**WEST SUSSEX COUNTY COUNCIL
STRATEGIC PLANNING CONSULTATION**

DATE: 14-01-2014

**TO: Arun District Council
FAO: Simon Davies**

**SUBJECT: AL/95/13 - Outline planning application for 3 x detached houses with garaging -
This is a Departure from the Development Plan.**

Drawing Name
Site Layout Plan

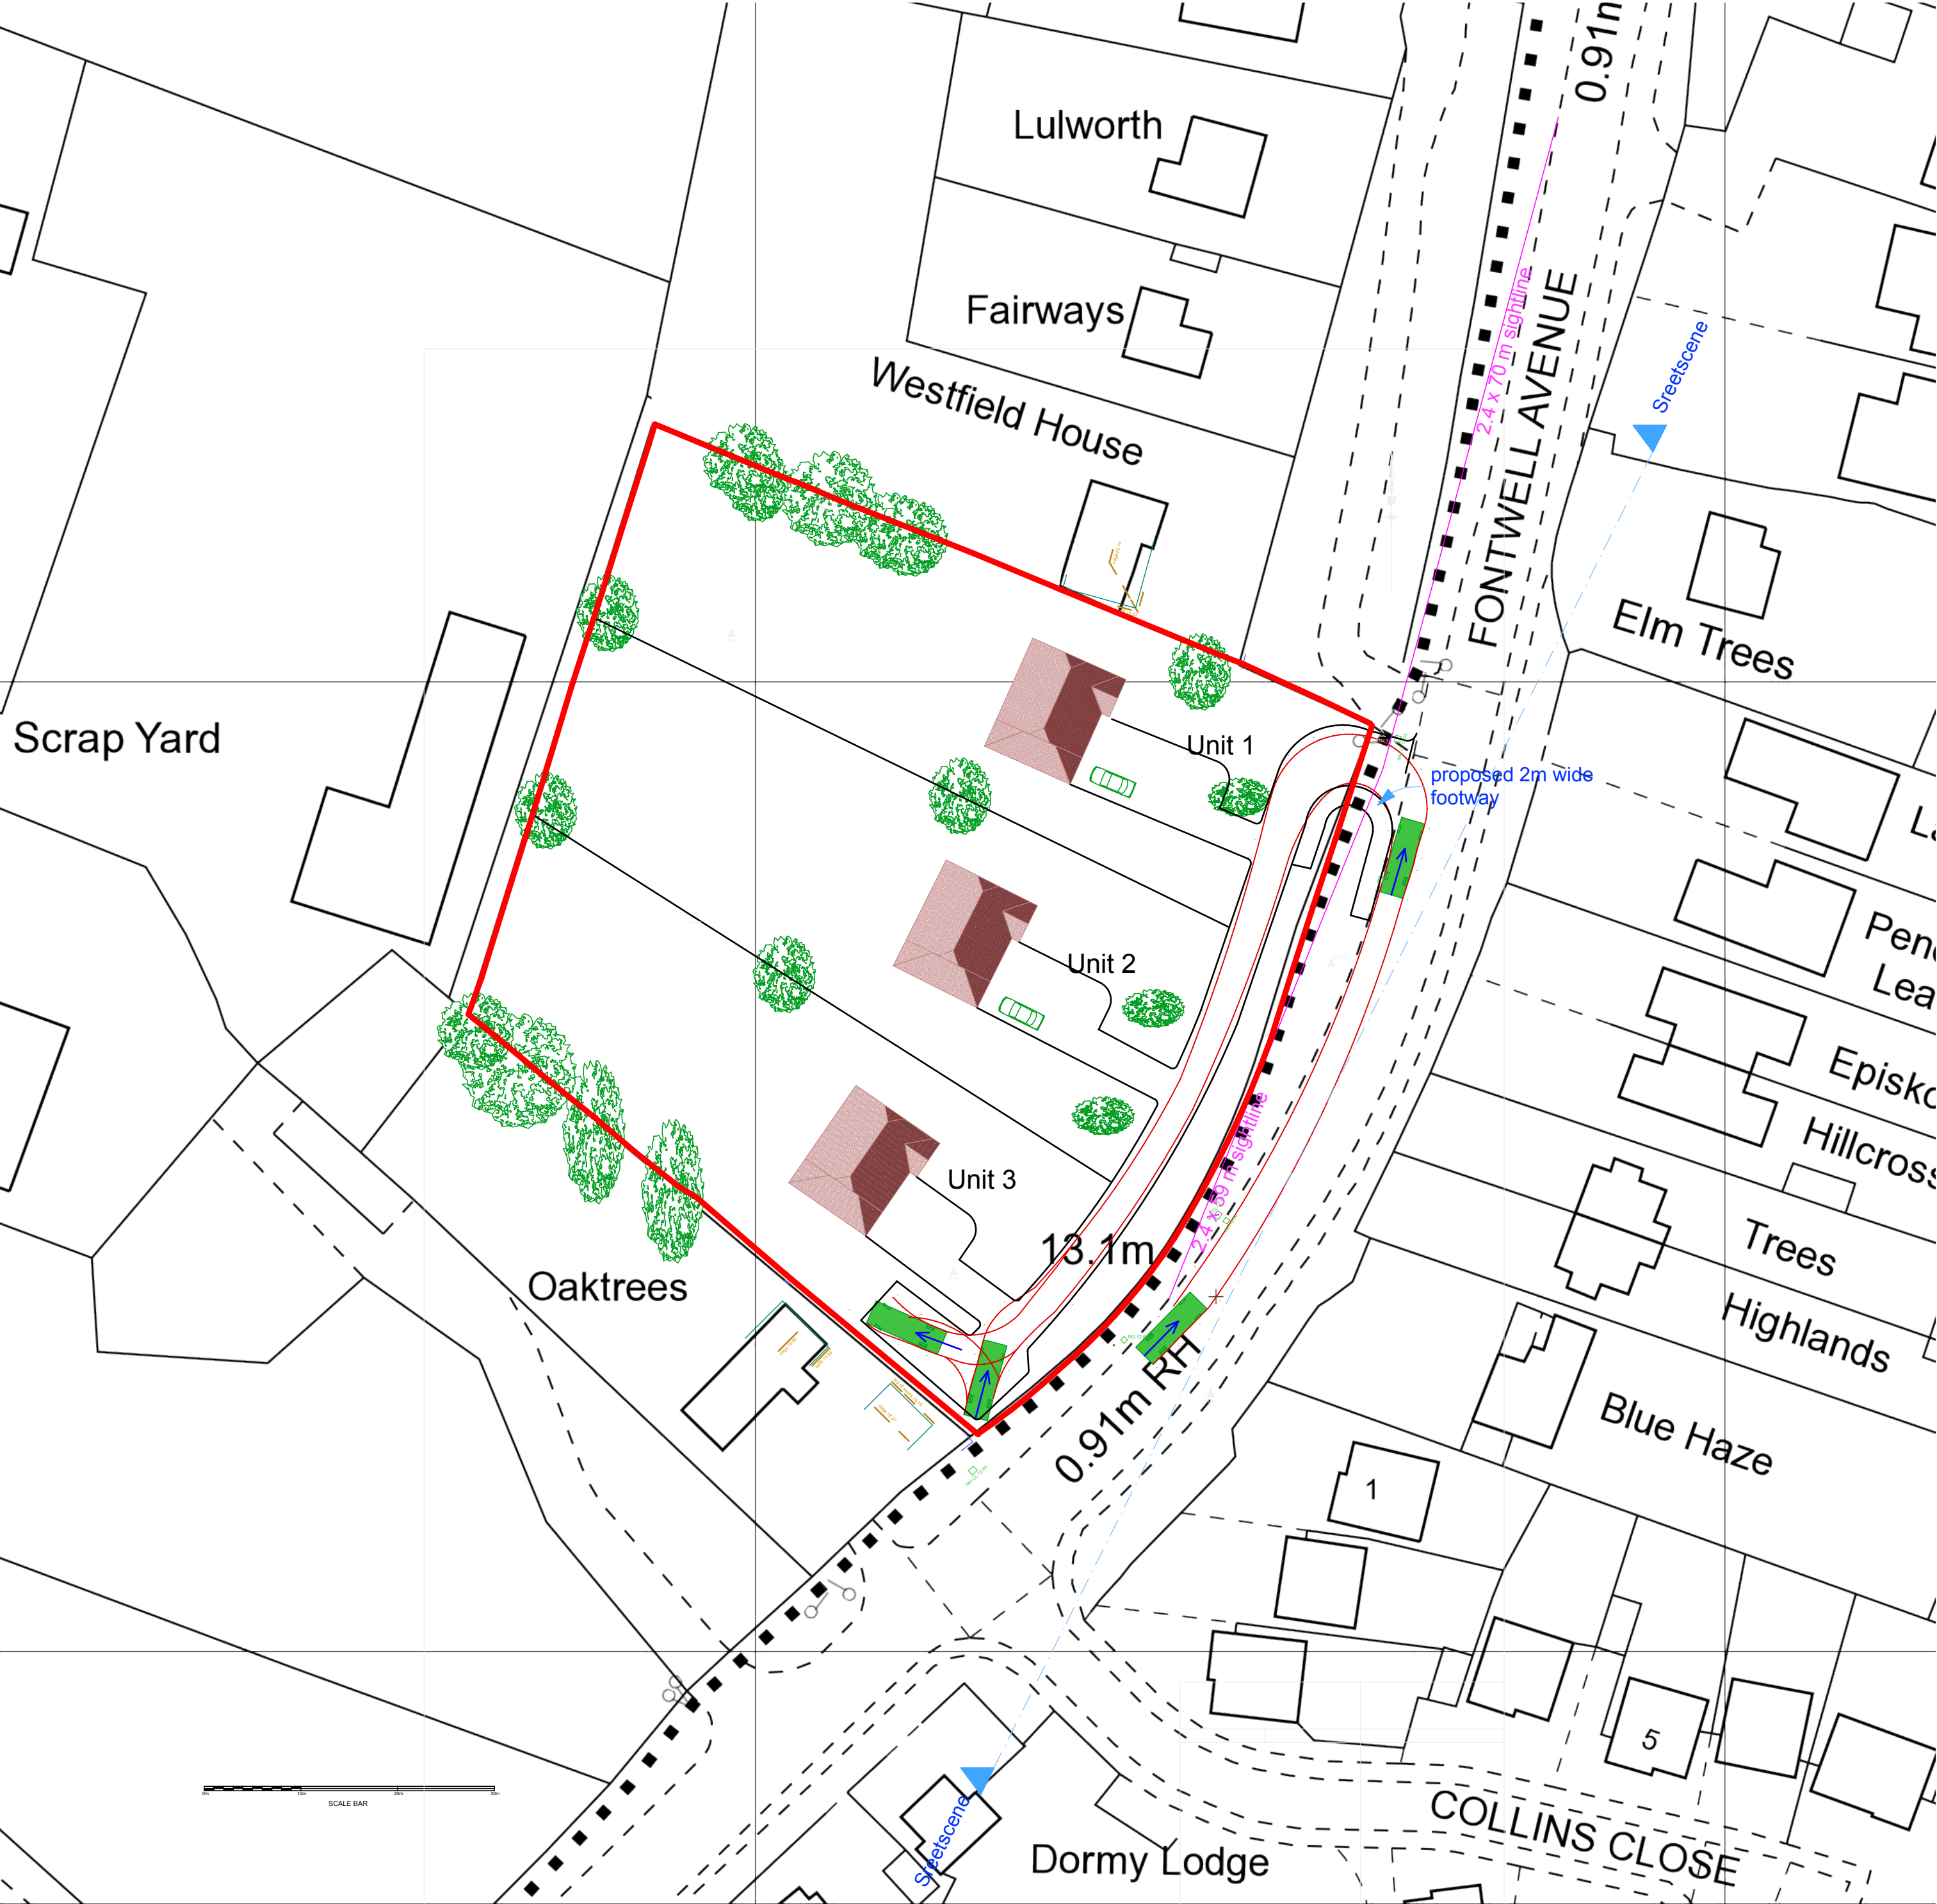
It is proposed for the site to create a shared access way for the 3 dwellings to utilise, extending from an existing agricultural access to the north east of the site to the south east. It is worth noting a similar private road arrangement is in place directly to the north of this site that serves 4 dwellings and the access to this application site will be served off the same existing dropped kerb. It is stated within the Design and Access Statement that access improvements are proposed and widened to 6m to safely allow for two opposing vehicles to pass each other when entering and exiting on to Fontwell Avenue. The remaining access way width can then be reduced to 4.1m to still allow for opposing vehicles to pass. A turning head is in place at the end of the road which has been shown via swept path analysis that a larger vehicle, such as a waste collection lorry, can enter and turn and subsequently exit on to Fontwell Avenue in the forward gear. However, measurements have not been shown on the submitted plan and therefore the applicant should make themselves aware of the measurements of waste collection lorries and the dimensions of the turning head required.

With regards to the access visibility, the applicant has undertaken an automatic traffic counter which also recorded the speeds in the site's access vicinity. An average 85th percentile of these speed results has been taken to calculate the required visibility splays. The outcome of this survey is stated to be 38mph northbound and 37.8mph southbound. Before formal approval by the Highway Authority can be given, we would first require the full ATC data as it does not appear to be available to view on the planning website. However, the stated visibility splays

said to be achievable is 2.4m x 70m to the north and 2.4m x 59m to the south which, going by Manual for Streets and taking in to account the speed survey data, this meets the requirements in both directions. These splays should be free from obstructions of 0.6m in height and conditioned to any planning consent.

The proposals include for the addition of a 2m wide pedestrian footway adjacent to the south of the access to provide a better crossing facility for residents and visitors. This and the access may be required to be entered in to section 278 Agreement with the Highway Authority, details of who to contact are below.

The application provides 2 off-street parking spaces within internal double garages and would also appear additional space on the driveway is available. Having checked this against WSCC's car parking demand calculator it would meet the minimum standards for a development of this size in this area. Secure and covered cycle parking is also advised to offer an alternative travel option in this sustainable location. As said previously, turning on site is achievable, allowing a car to exit on to Fontwell Avenue in the forward gear.

In principal, no concerns would be raised to this application from a highway safety perspective subject to conditions securing the access, visibility splays, parking and turning and cycle parking.

Before WSCC can support this application, we would first require the full ATC data that relates to the traffic counts and speed data as previously mentioned. Please re-consult once this is available to view online.
